Tuesday, 29 August 2023

**Subject: Response to Submission Report for the Narwee Parklands Care Community State Significant Development Application (SSD-45024776)
59-67 Karne Street North, Narwee**

A220594 DA2004 C

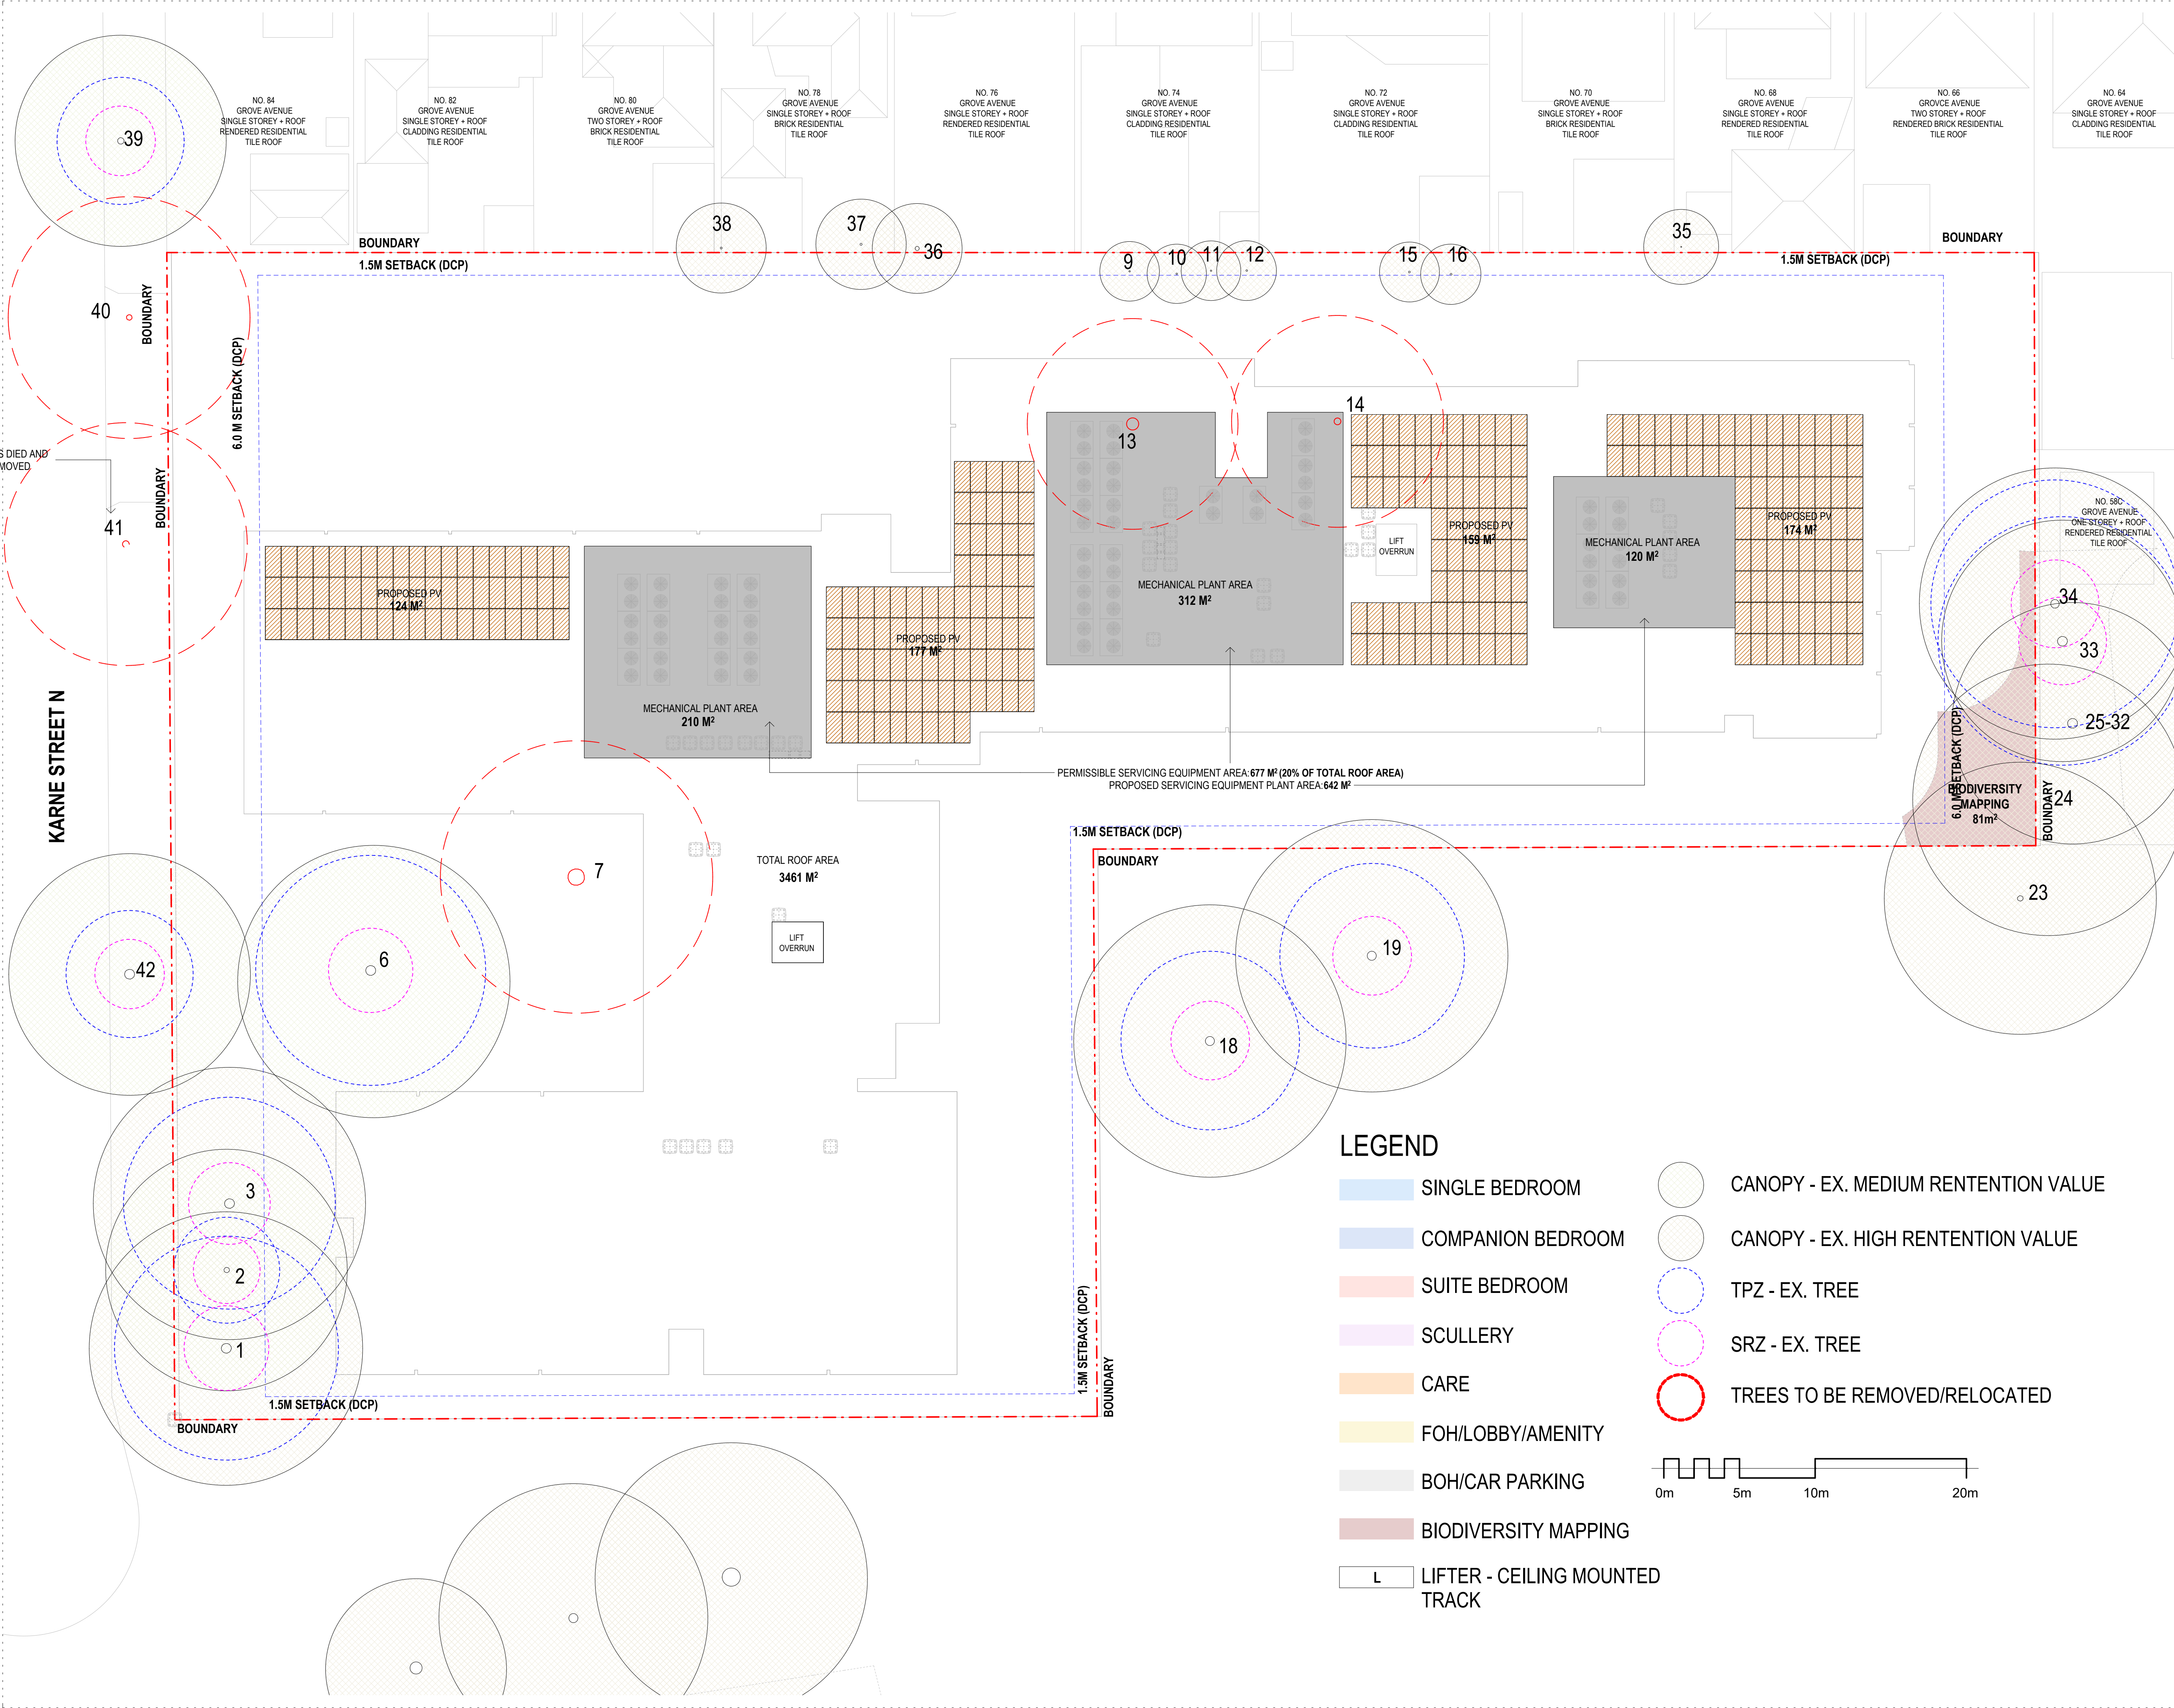
GSA / TB	(b) Areas for staff are located in the basement with little to no amenity for staff members during breaks. This is contrary to comments from the State Design Review Panel (SDRP) and principles within the draft Seniors Housing Design Guide November 2022 (previously November 2021). Therefore, the proposal must be amended to address the above amenity concerns related to the current design.	A separate Staff Room has been added to Ground Level near Multi-Purpose Room. Staff Breakout Area has also been proposed at the southern courtyard to improve staff amenities.	Refer to Architectural DA2001[F] & Landscape drawings
GSA	(a) The placement of the mechanical plant does not appear to be integrated with the design of the roof as required by the provisions of the Housing SEPP. The mechanical plant on the roof is to be amended to be setback a minimum of 2m from the edge of the roof to minimise visibility from surrounding properties and the public domain.	Roof plants have been amended to be setback to minimum 2m from edge of roof. Acoustic screening has been provided to conceal roof services plant.	Refer to DA2004[F]

GSA	Further to the comments with regards to noise previously outlined, the architectural plans must be amended to demonstrate any acoustic screening that may be required. Additionally, the RL's of any such screening, the roof parapet, the lift overruns, PV cells and other plant must be indicated on the roof plan, elevations and sections.	Required RL's are now shown on roof plan, elevations and sections.	Refer to DA2004[F], Elevations and Sections
GSA	The area of mechanical plant of the roof appears to exclude the area of the lift overruns and other plant. These areas are to be revised on the architectural plans and included in the calculation of area of mechanical plant that must not exceed 20% of the surface area of the roof in accordance with the Housing SEPP.	Coordinated roof services plant area is 16% of total roof area.	Refer to DA2004[F]
GSA	Details of any discharge of basement exhaust is to be submitted and indicated on the plans.	Services exhausts are reflected on Roof Plan.	Refer to DA2004[F]

1 DEEP SOIL INCLUDING BIODIVERISTY
1 : 600

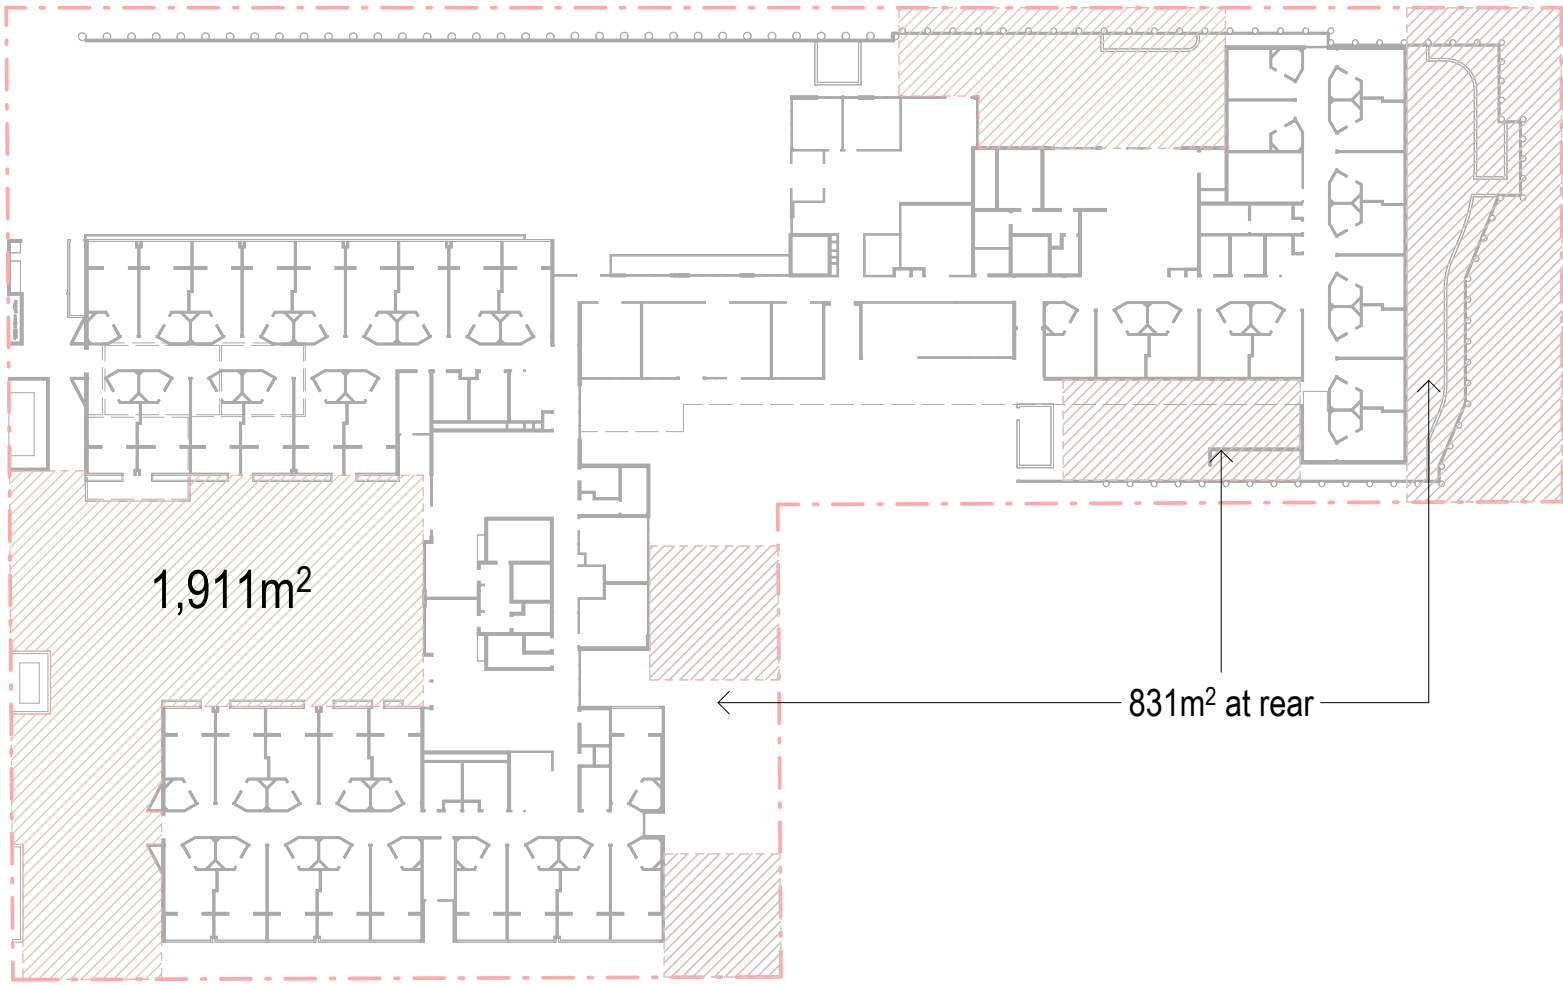
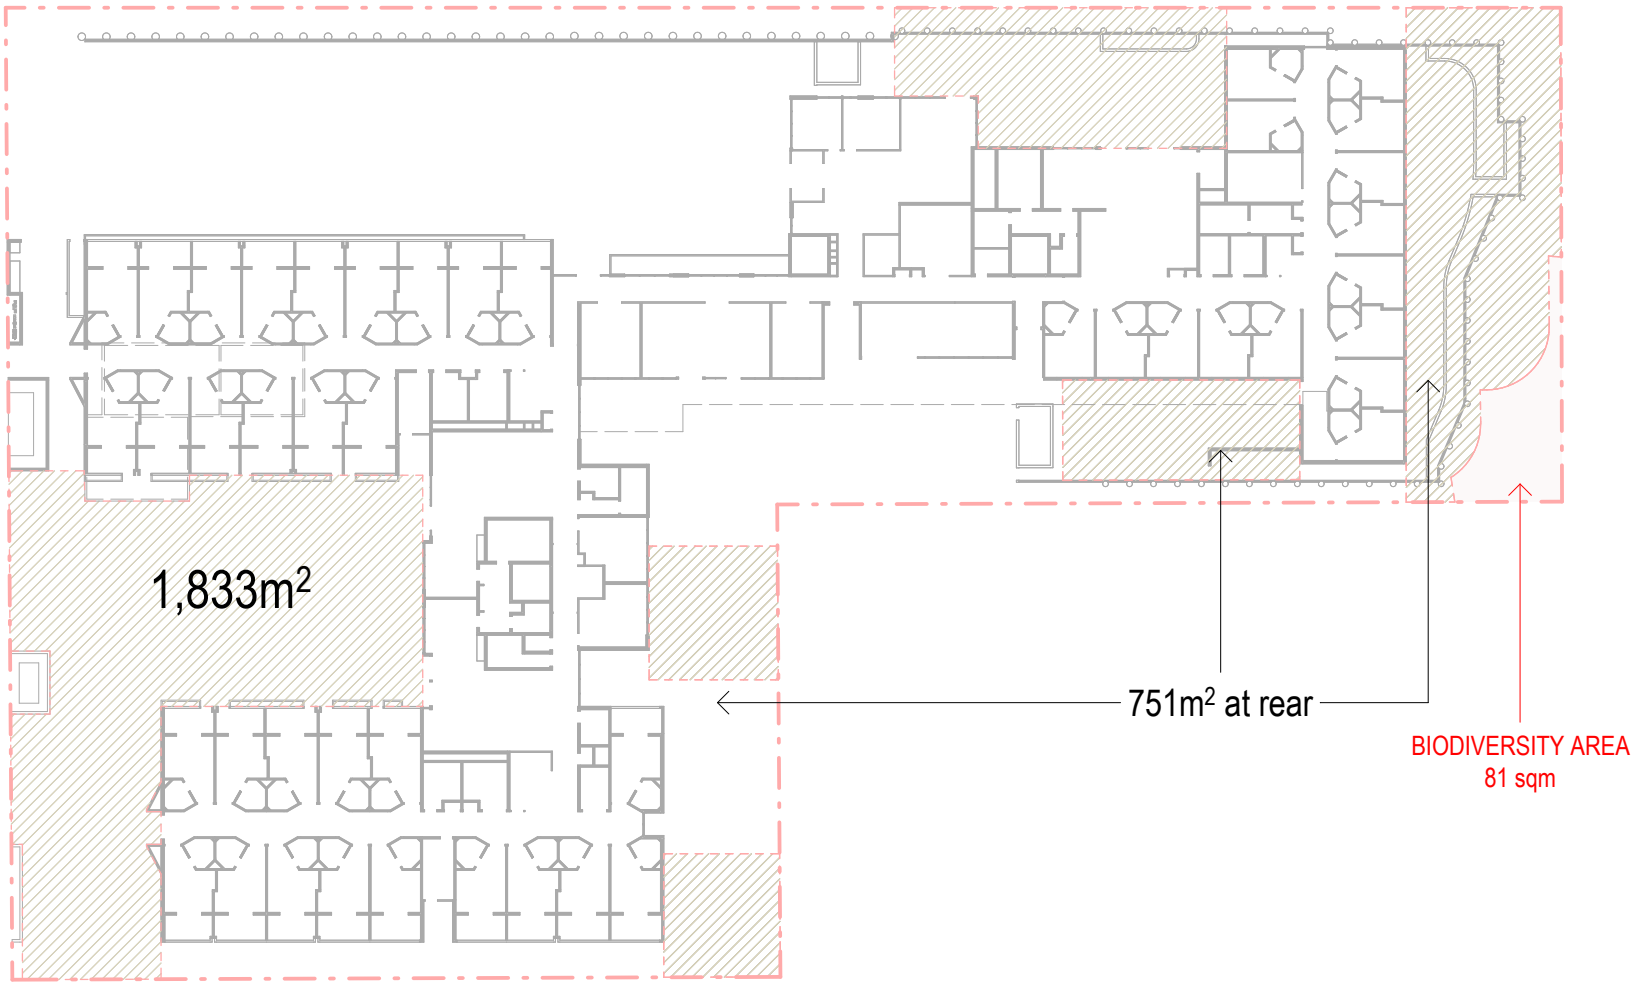
Agency / Organization	Agency Reference	Comment from Agency / Organization	Section Reference / Response
GSA / TB	(c) Deep soil zones indicated on the architectural plans and identified in the design report do not meet the definition for deep soil as prescribed by the Housing SEPP as follows: deep soil zone means a landscaped area with no buildings or structures above or below the ground. Therefore, the calculation of deep soil to be revised in accordance with this definition.	Architectural and landscape have revisited deep soil compliance calculations. The revised deep soil zone has minimum dimensions of 6m and have excluded: - <ul style="list-style-type: none"> • Basement • Impervious Surfaces • Timber Deck • Concrete Footpath • Unit Paving • Undercroft of building structure Required 15% of total site area. Provided 15% (excluding biodiversity areas)	Refer to Architectural DA4103[D] & Landscape drawings

17/08/23 - RTS Response comments			
GSA / TB	The plans still describe areas that are paved and have structures above (such as the café deck) as deep soil and landscaping areas. The deep soil and landscaping calculations are to be amended in accordance with the original comments made by the Department in the RtS letter dated 24 March 2023.	Architectural and landscape have revisited deep soil compliance calculations. The revised deep soil zone has minimum dimensions of 6m and have excluded: - <ul style="list-style-type: none"> • Basement • Impervious Surfaces • Timber Deck • Concrete Footpath • Unit Paving • Undercroft of building structure Required 15% of total site area. Provided 15% (excluding biodiversity areas)	Refer to DA4103[D]
